Re: J0324-1638  
Lot 41 Woodbridge South

The truss drawing(s) referenced below have been prepared by Truss Engineering Co. under my direct supervision based on the parameters provided by Comtech, Inc - Fayetteville.

Job	Truss	Truss Type	Qty	Ply	Lot 41 Woodbridge South	165990023
J0324-1638	F01	Floor	5	1

Truss Placement Plan
 SCALE: NTS

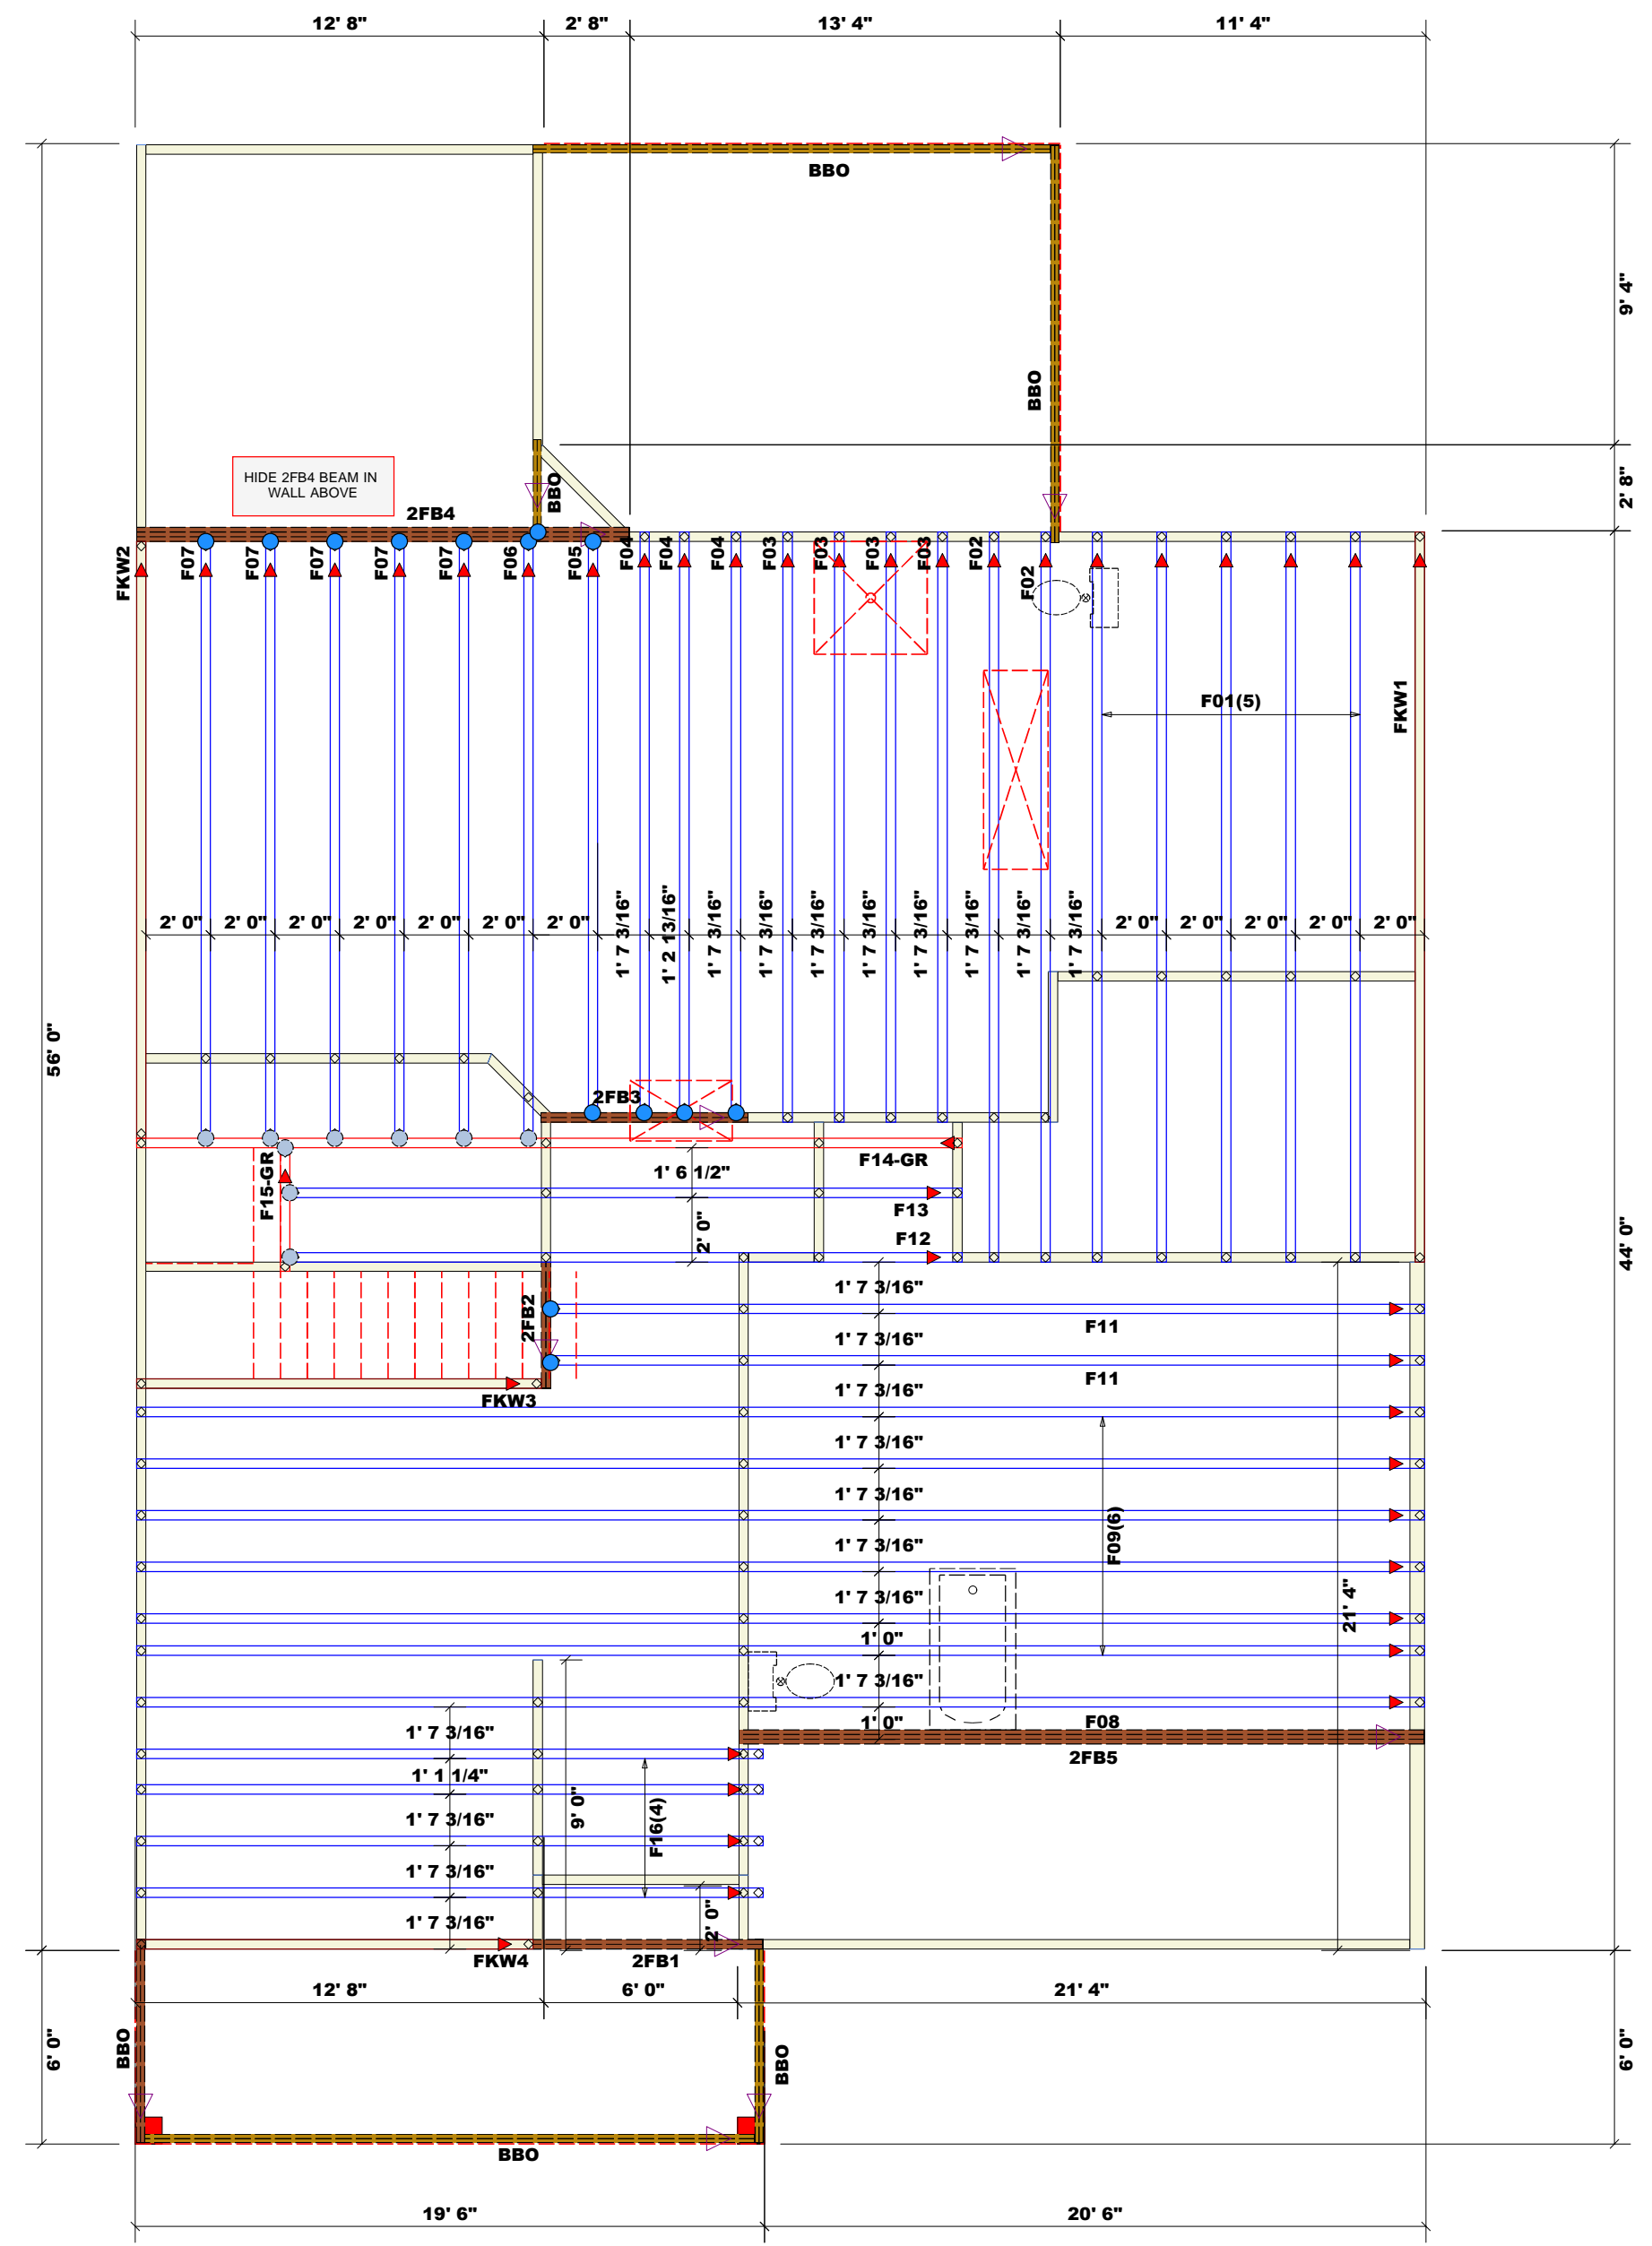
REPAIR: 10" LONG CRACK ON TC AND BC STARTING AT 4'-6" FROM RIGHT END.

APPLY 1.75" X 14" LVL SCAB TO ONE FACE OF TRUSS.  
ATTACH WITH ONE ROW OF (0.131" X 3.5") NAILS SPACED  
2" O.C. INTO EACH COVERED TRUSS MEMBER.  
MINIMUM LVL SPEC: {FB=2650 PSI, FV=250 PSI, E=1,900,000 PSI}  
IN ADDITION TO REQUIRED NAILING, CONSTRUCTION QUALITY  
ADHESIVE RECOMMENDED TO REDUCE POTENTIAL SQUEAKS.

ATTACH < 2 LAYERS > 3/4" PLYWOOD OR OSB GUSSET (23/32" RATED SHEATHING 48/24 EXP 1)  
TO ONE FACE OF TRUSS WITH ONE ROW OF (0.131" X 3.0") NAILS SPACED 2" O.C. INTO EACH  
COVERED TRUSS MEMBER. GLUE PLYWOOD LAYERS TOGETHER PRIOR TO ATTACHING TO TRUSS.  
IN ADDITION TO REQUIRED NAILING AND GLUED LAYERS, CONSTRUCTION QUALITY  
ADHESIVE RECOMMENDED AT TRUSS/GUSSET INTERFACE TO REDUCE POTENTIAL SQUEAKS.
